Lime Down Solar Park

**Planning Inspectorate Reference:
EN010168**

**Wiltshire Council Comments on Submissions
Received at Deadline 5**

Deadline 6 (21 August 2026)

LIME DOWN SOLAR PARK
Figure 3-4-4.1
Lime Down Solar Park - Site D Sheet 1
Landscape and Ecology Mitigation Plan - Revision 4
END10168/APP/6.2
5(2)(a)

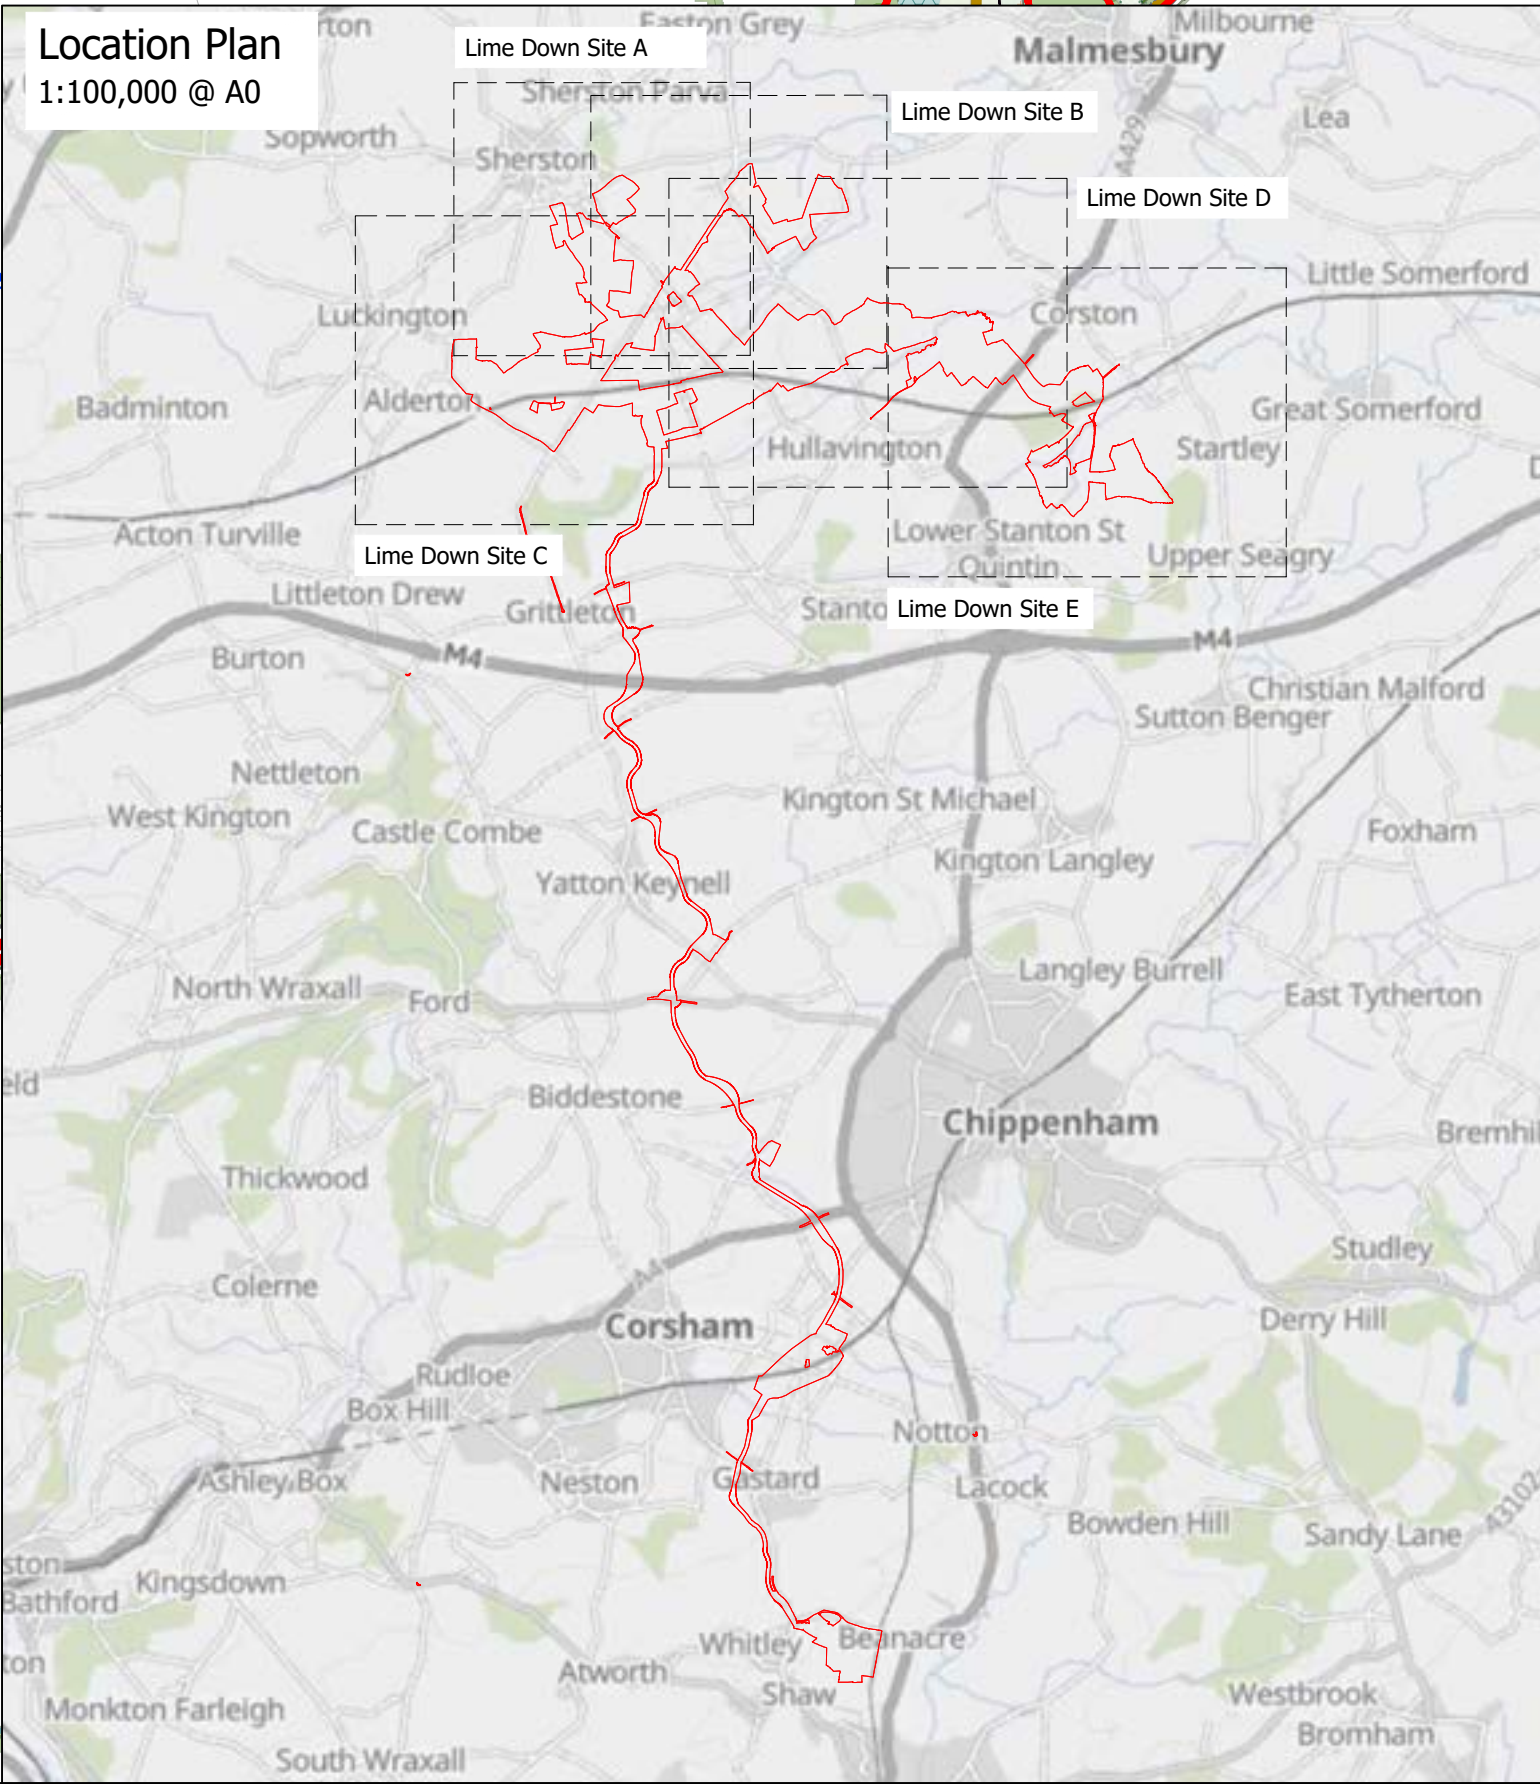
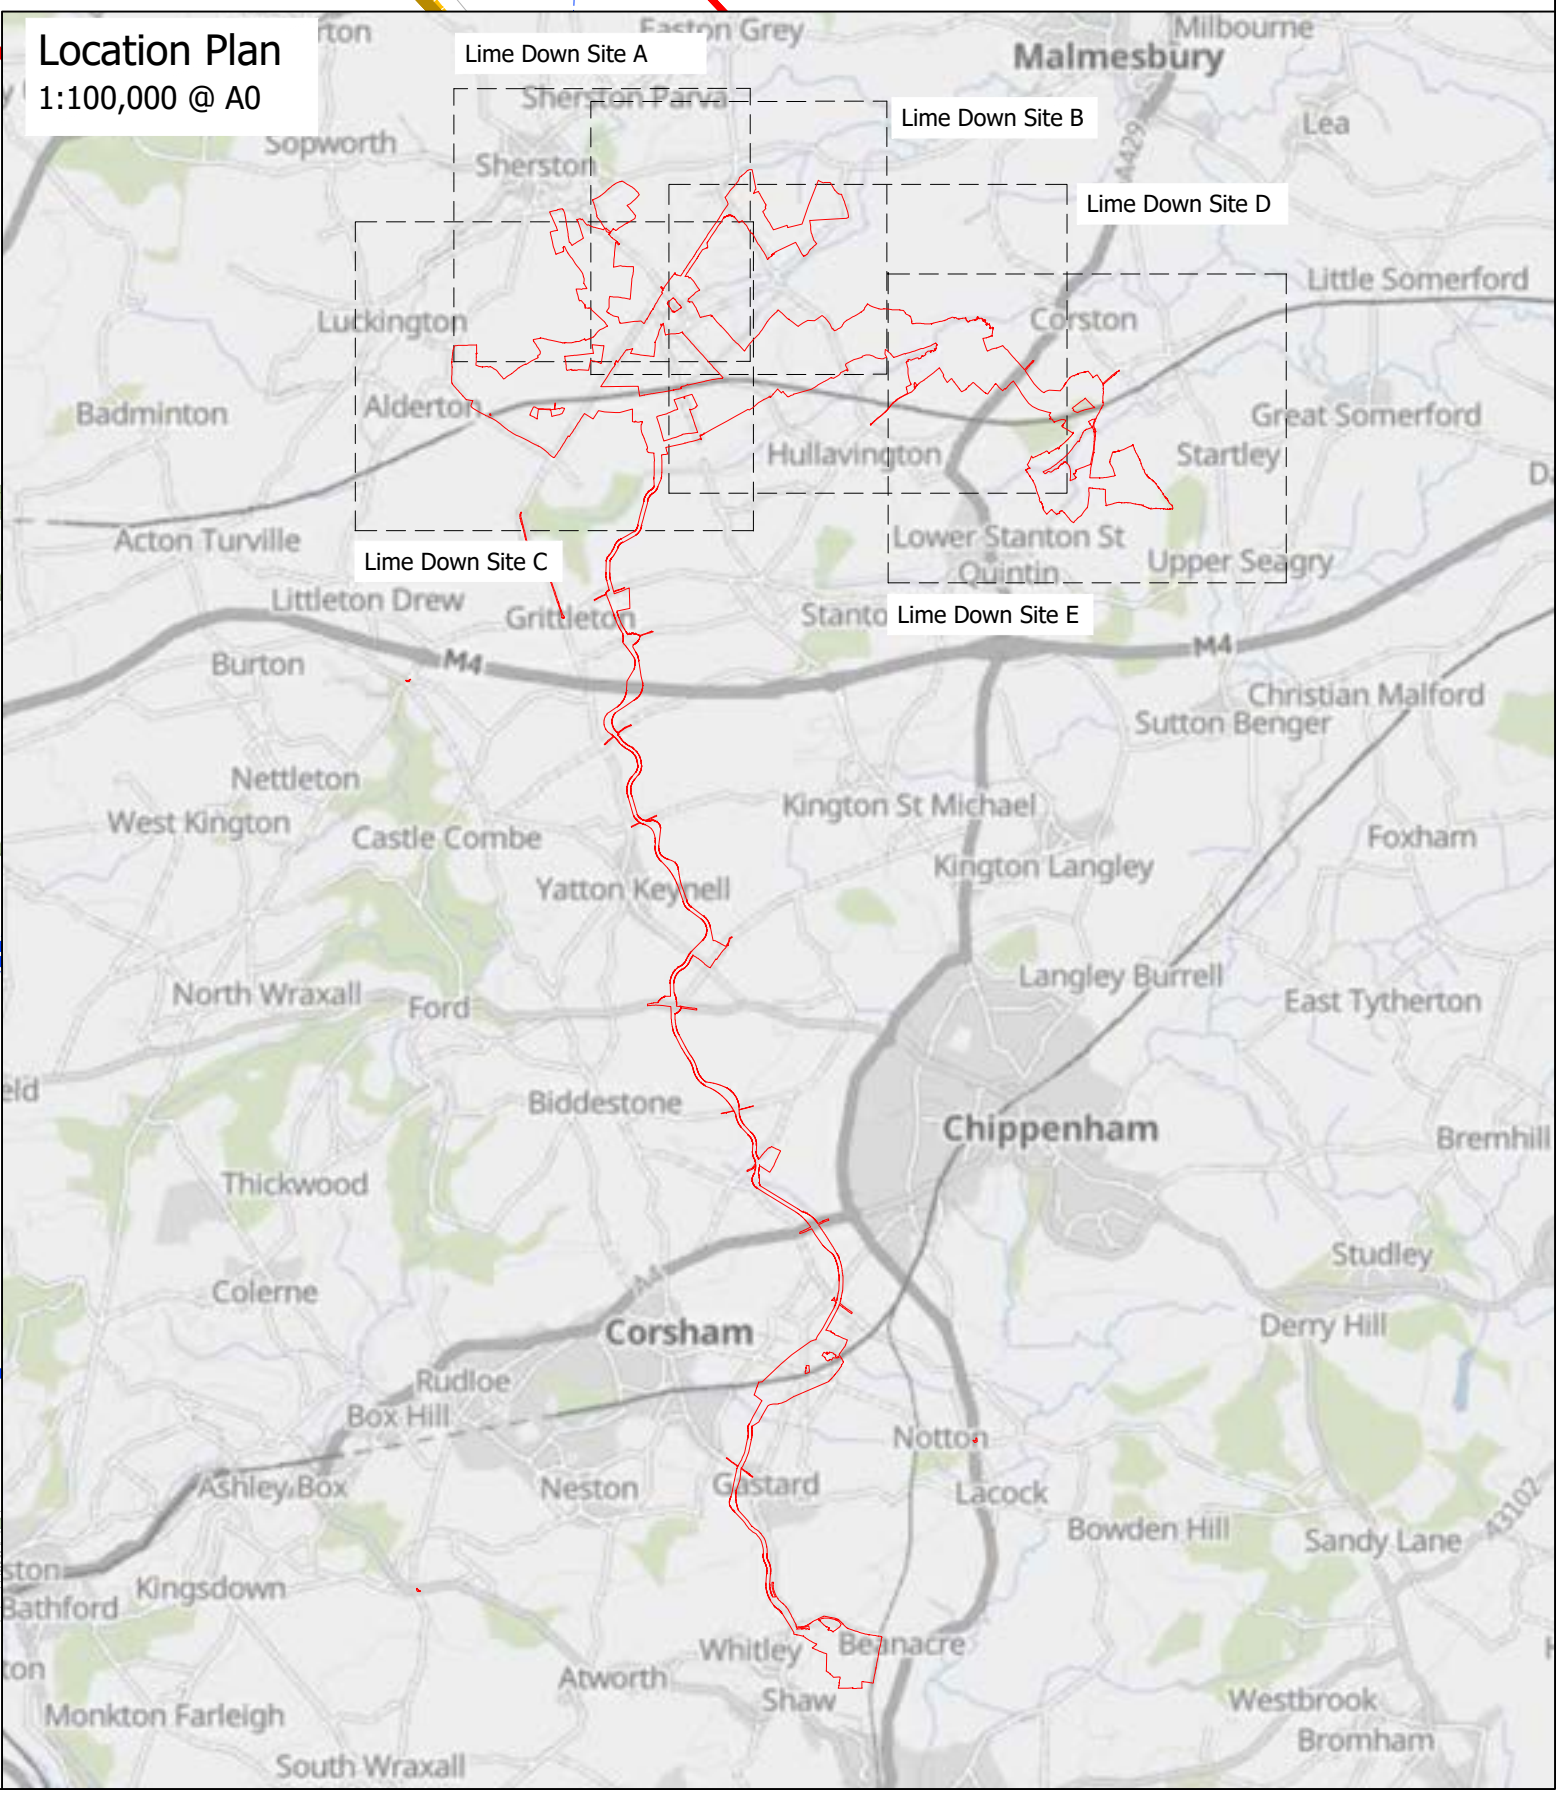
The Council considers that the 'Landscape and Ecological Mitigation Plans' **[REP5-039; 040; 041; 042]** should be revised to differentiate between the different internal access track / road functions, with different keyed line-type colours, as they are all currently the same light brown colour, so specific routes and the differences within illustrative construction details **[REP5-066]** are not clear on the plans. The Council suggests the following three types of internal access tracks could and should be separately keyed and illustrated on plans;

- 1:2,500 @
-
- LIME DOWN SOLAR PARK**
Figure 3-4-5.1
Lime Down Solar Park - Site E Sheet 1
Landscape and Ecology Mitigation Plan - Revision 4
EN010168/APP/6.2
5(2)(a)

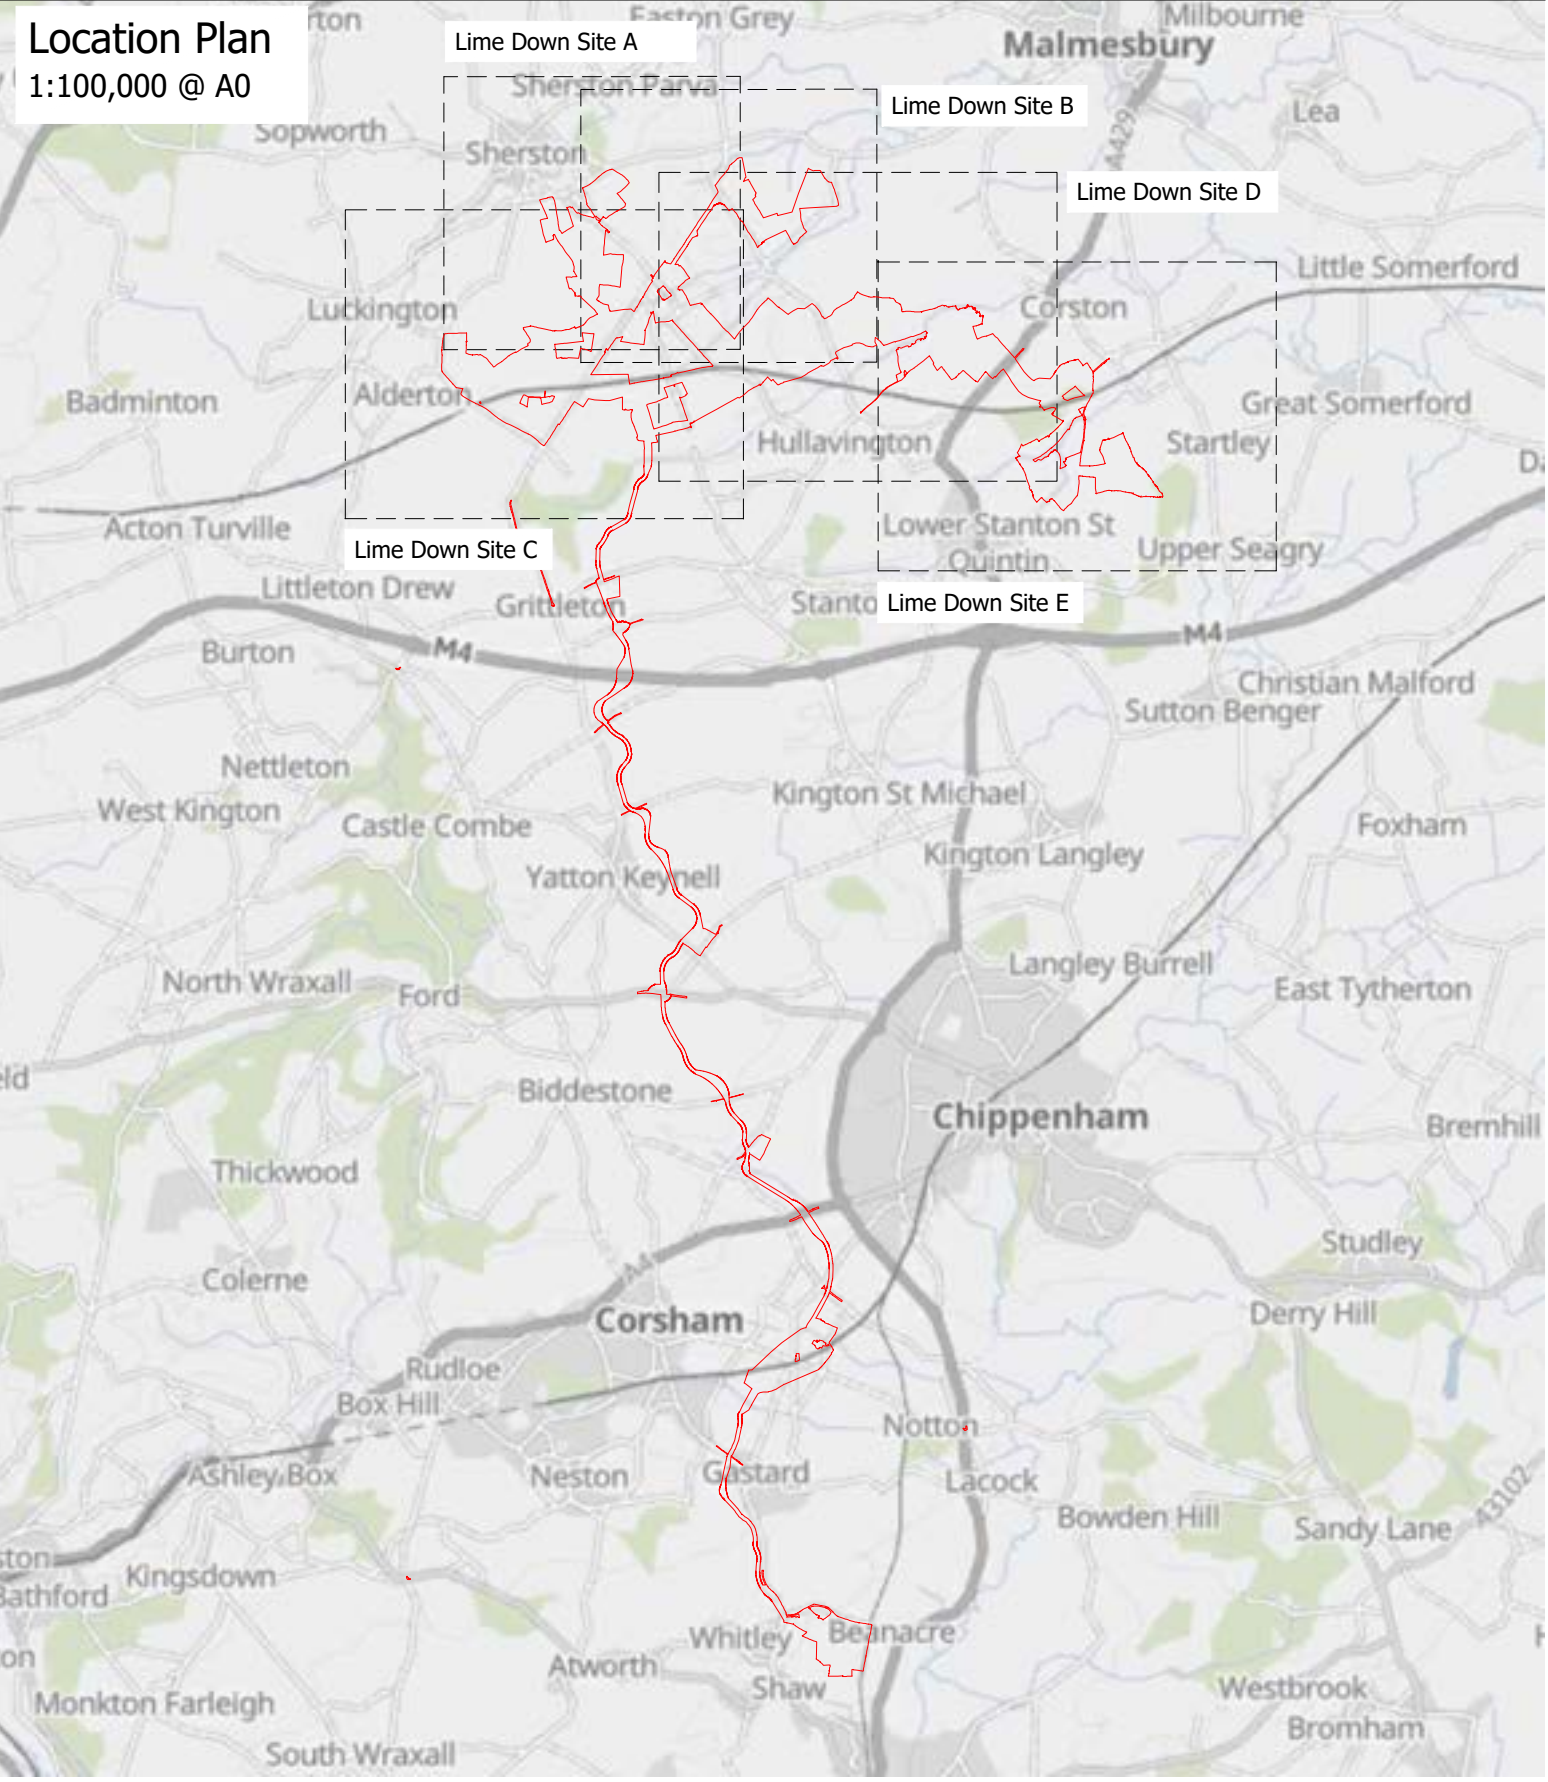
the Council observes that the original AIL route running along the northern edge of Bincombe Wood still remains on the Lime Down E Figures **[REP5-042]** in addition to the revised AIL track route around the northern and eastern edges of field parcel E3.
